From: Fiona Fitzgerald
Sent: 15 May 2019 14:30
To: Michael Eastham; Claire Potts; Planning.Responses
Subject: Saltbox BE/135/18/PL

Please find Environmental Health's comments below for this application. Requested conditions are in **bold**.

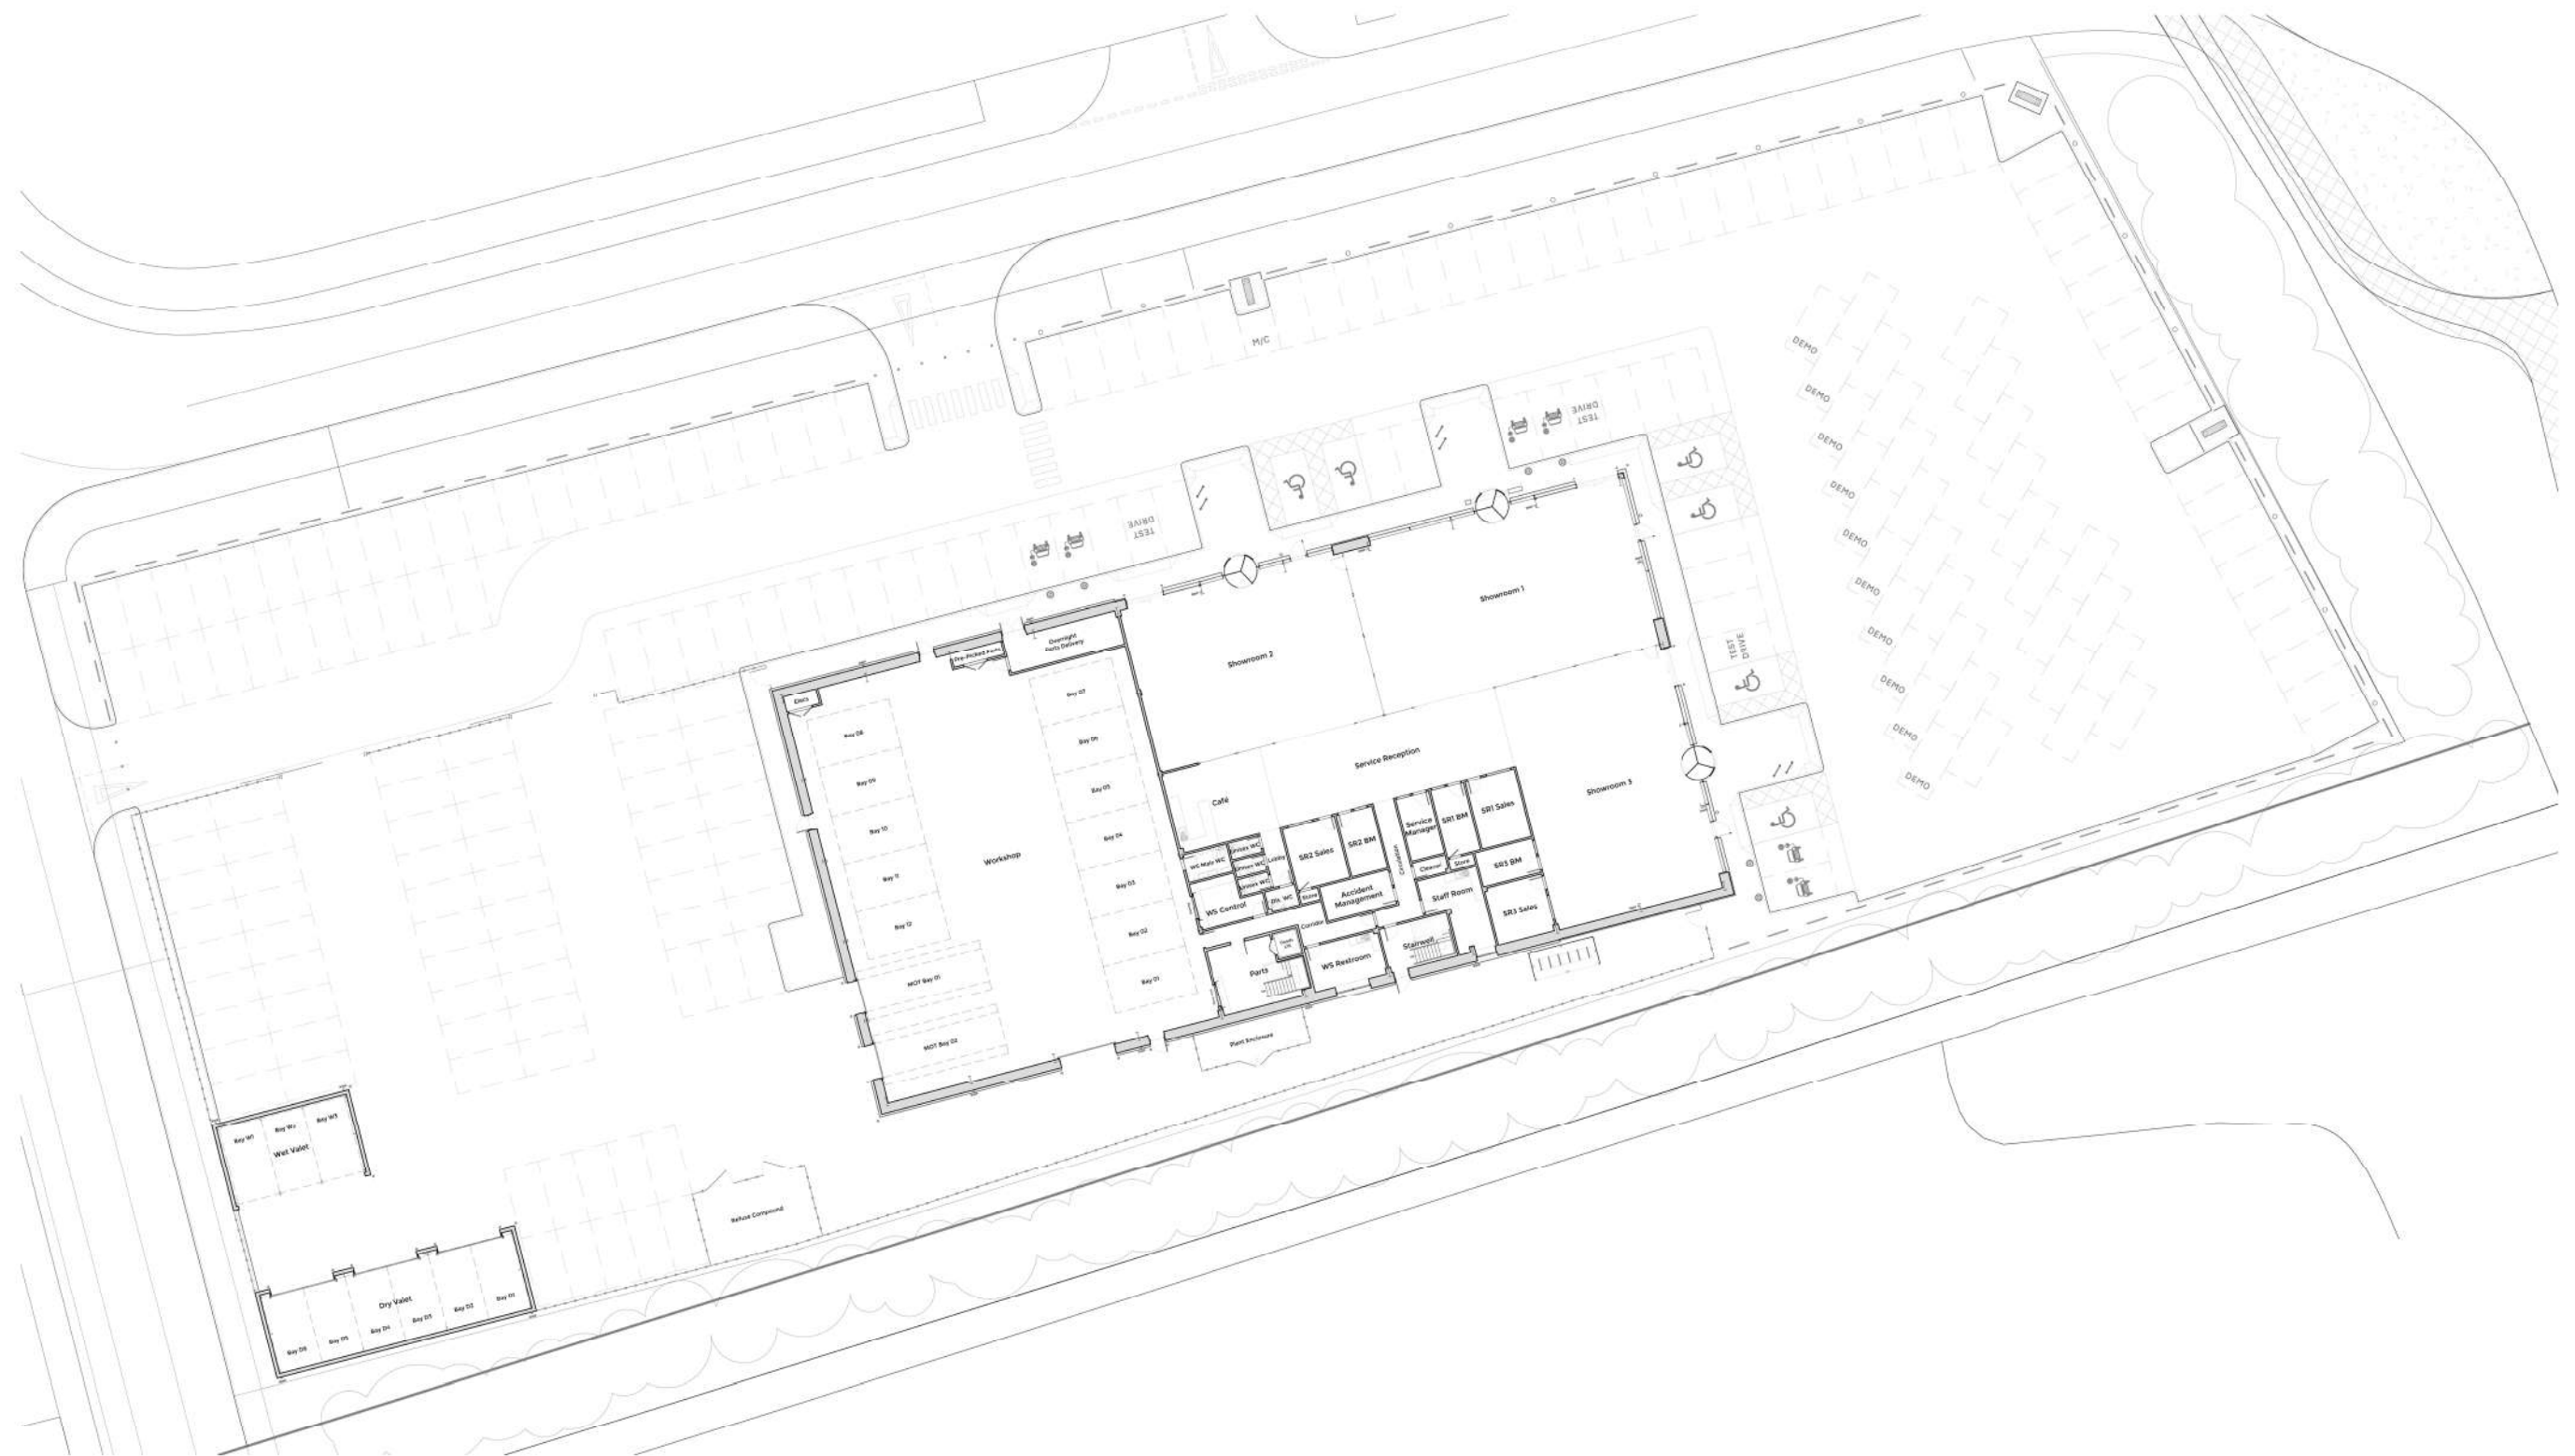
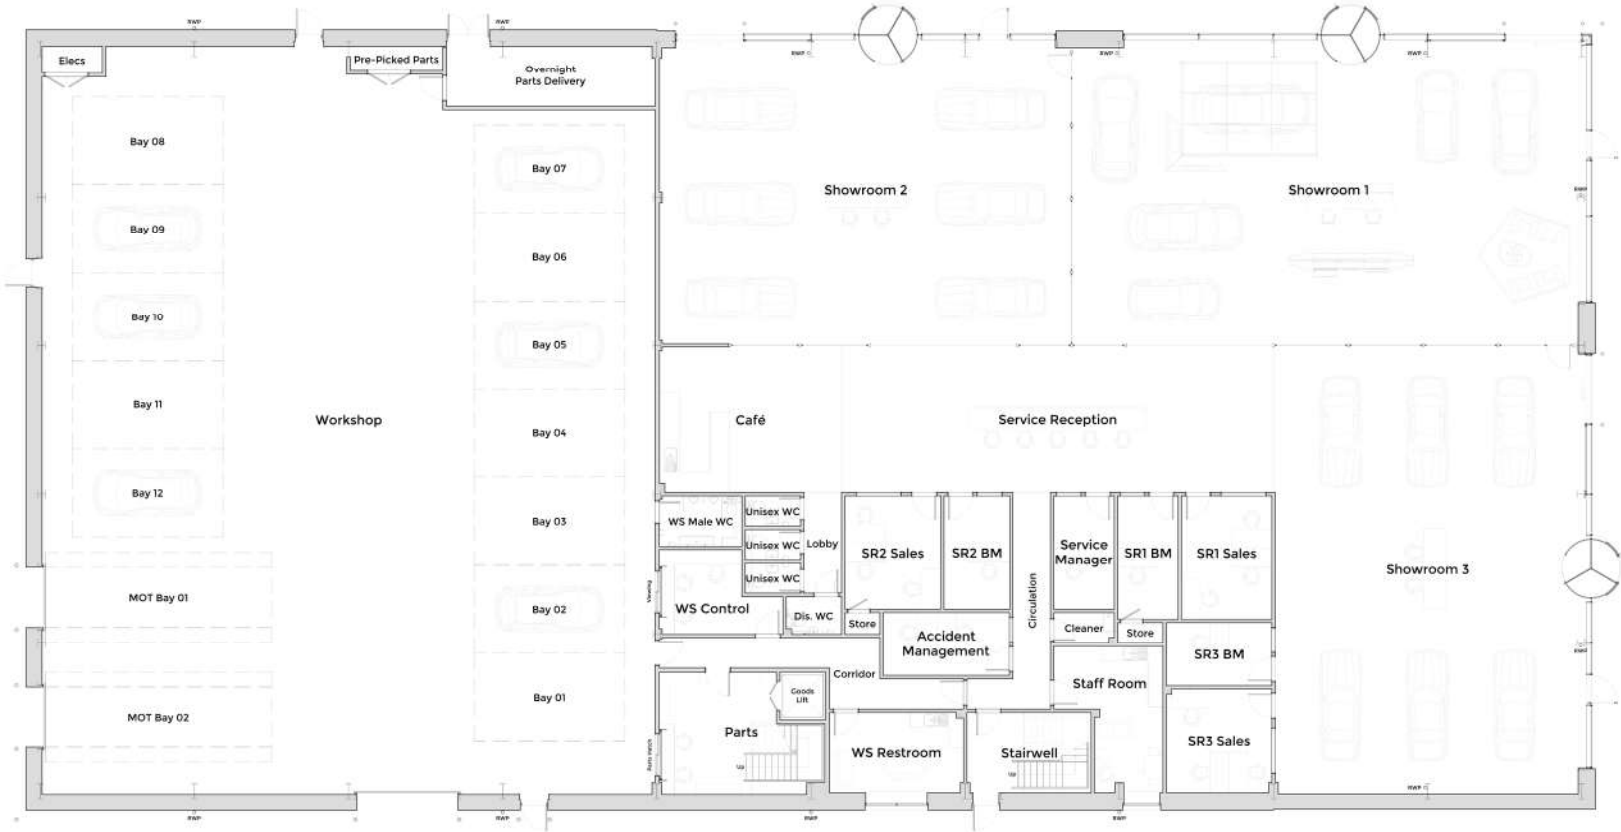
Environmental Health has serious concerns that the MOT/workshop of the Car Showroom has not been designed with noise mitigation in mind in relation to . The main workshop doors open to the South and are likely to be left open as is very common with car workshops and is located directly opposite the caravan park. There is no acoustic mitigation proposed for this. There are dry valet and wet valet areas shown to the south west of the car park which do not appear to have been included in the acoustic report and are likely to have a negative impact on the residents of the caravan site. The refuse bins have been placed on the southern boundary which is adjacent to the caravan site. It appears that an acoustic fence has been placed here but no mention of it has been made in the report. Therefore at this time, Environmental Health is of the opinion that noise from the car workshop/MOT part of the car showroom has not been adequately assessed and that there is a likelihood of negative impact on the residents of the caravan site.

A: With Acoustic Barrier Daytime L_{Aeq}

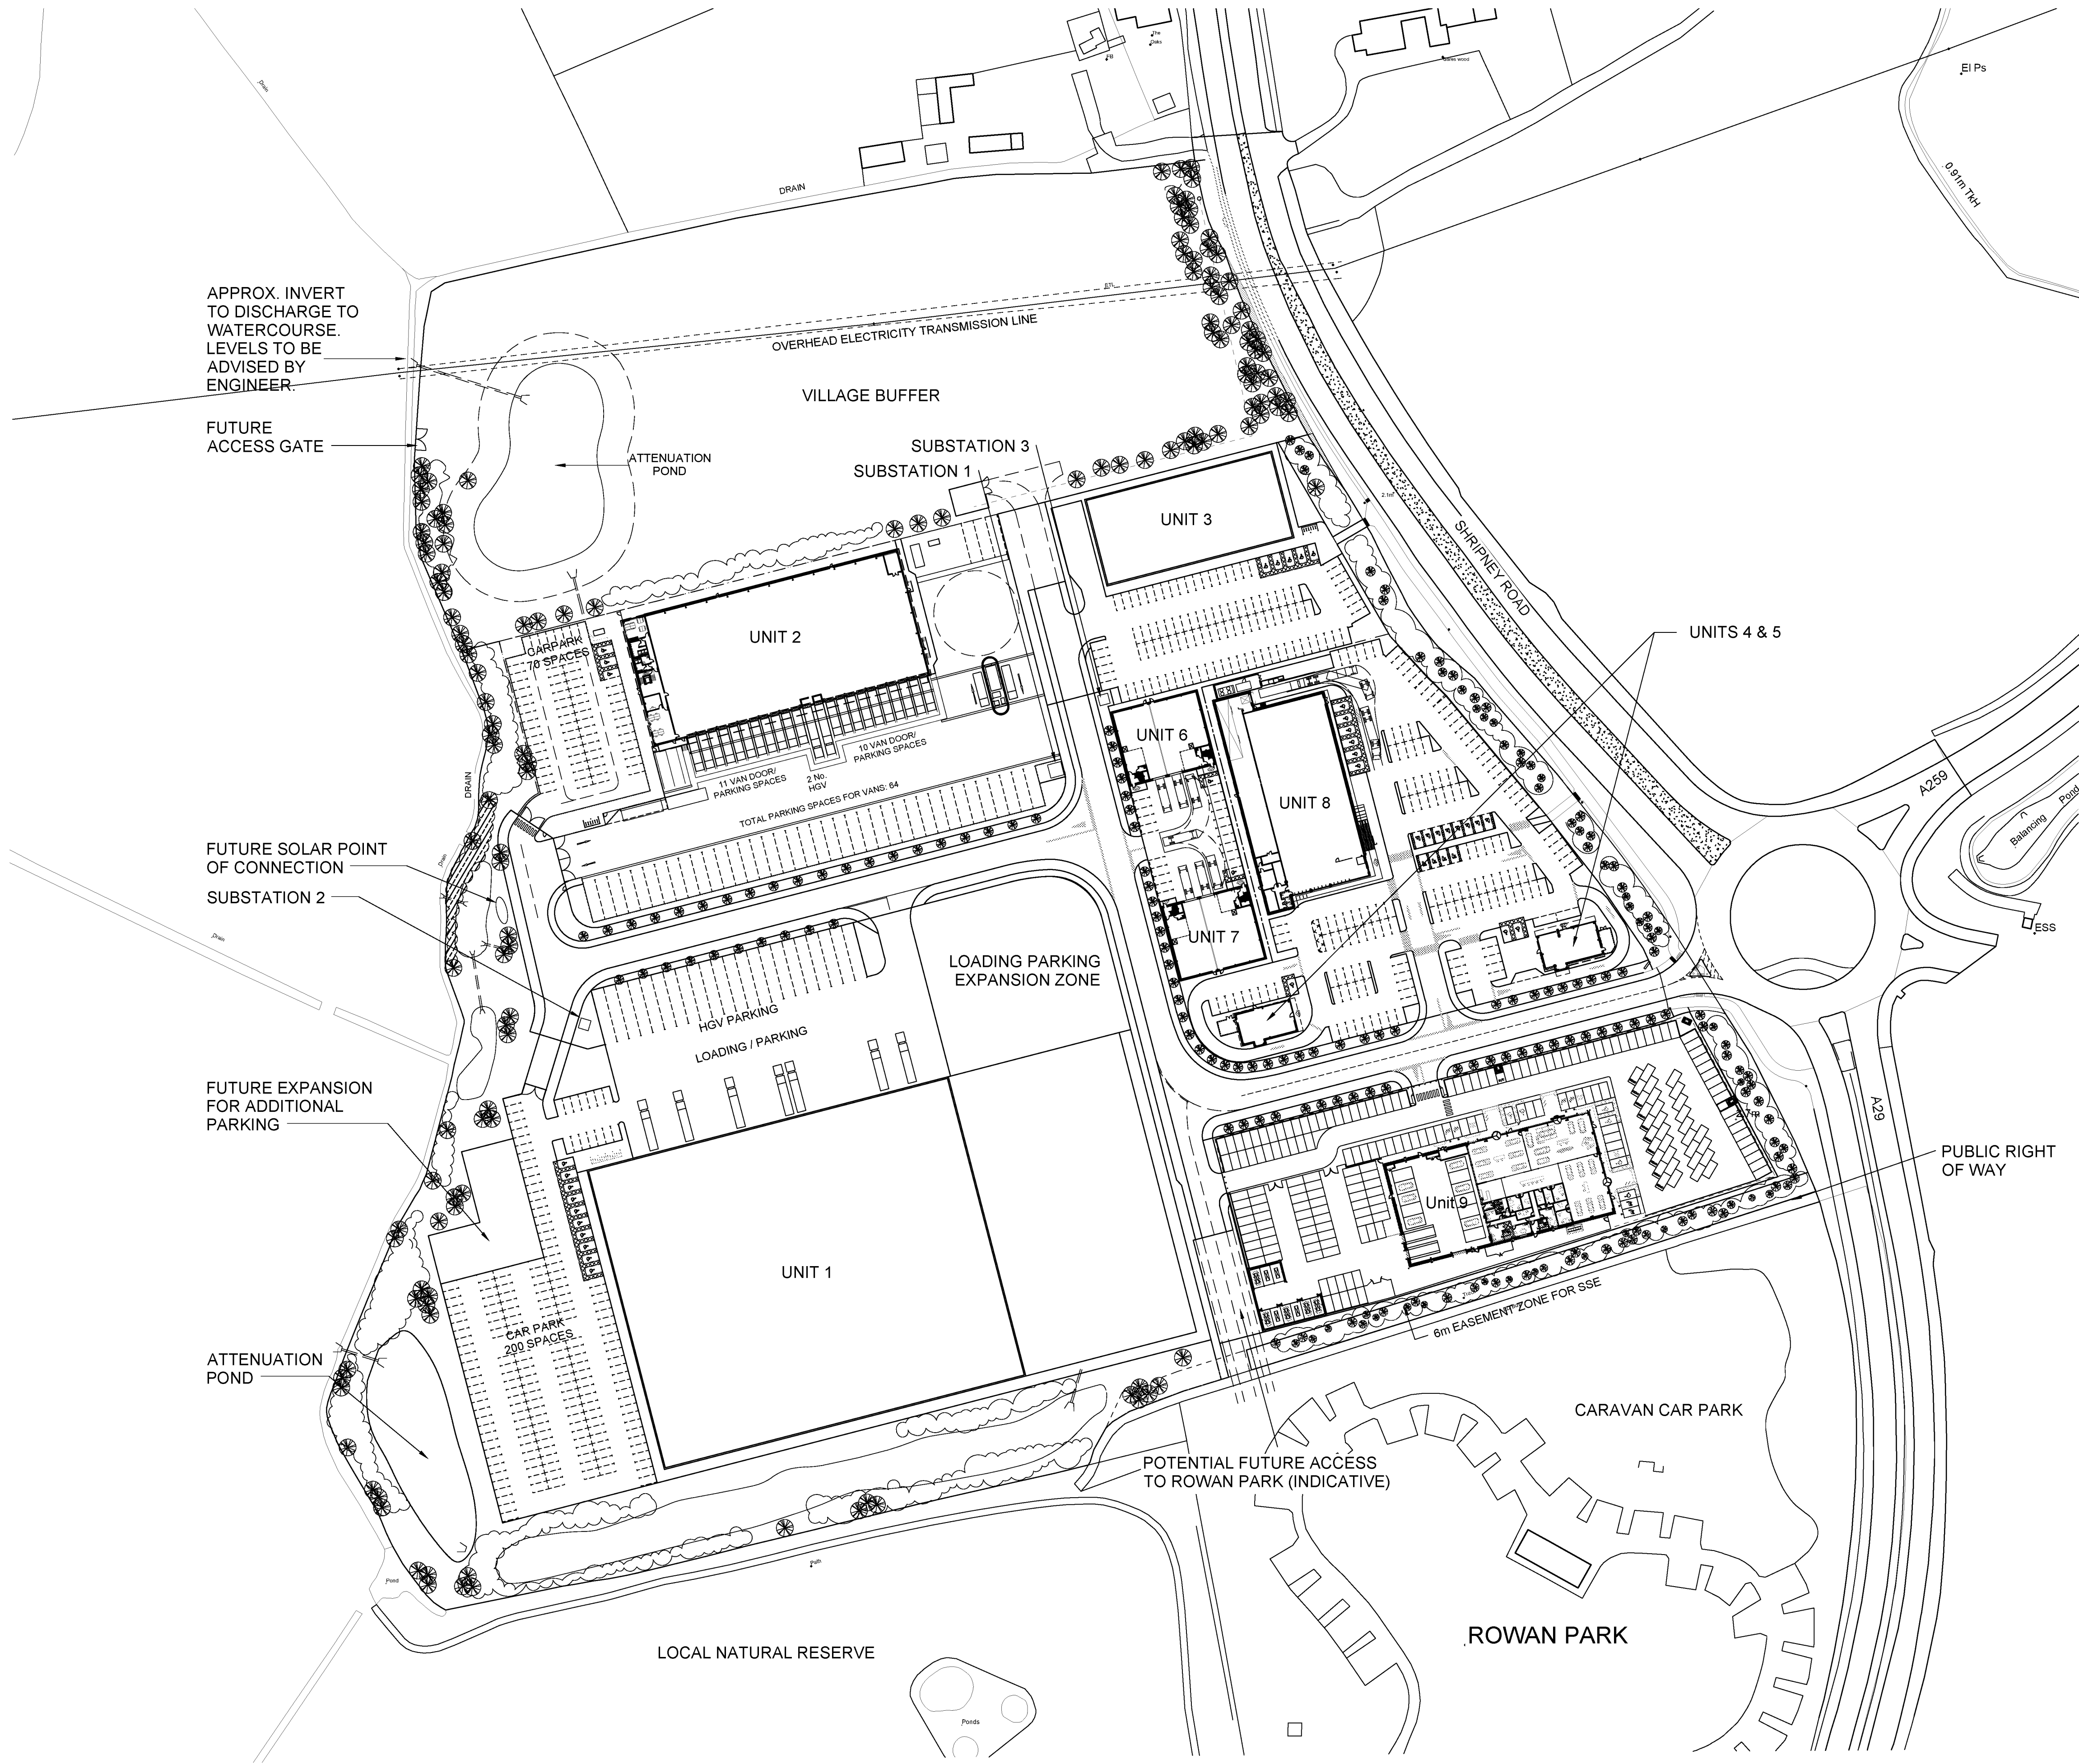
- 1.
- **The acoustic barrier shall be installed in accordance with the details in the acoustic report. It shall be installed prior to the occupation of Unit 2. Details of ongoing maintenance shall be submitted to and approved by the Local Planning Authority. Once approved the acoustic barrier shall be permanently retained and maintained.**
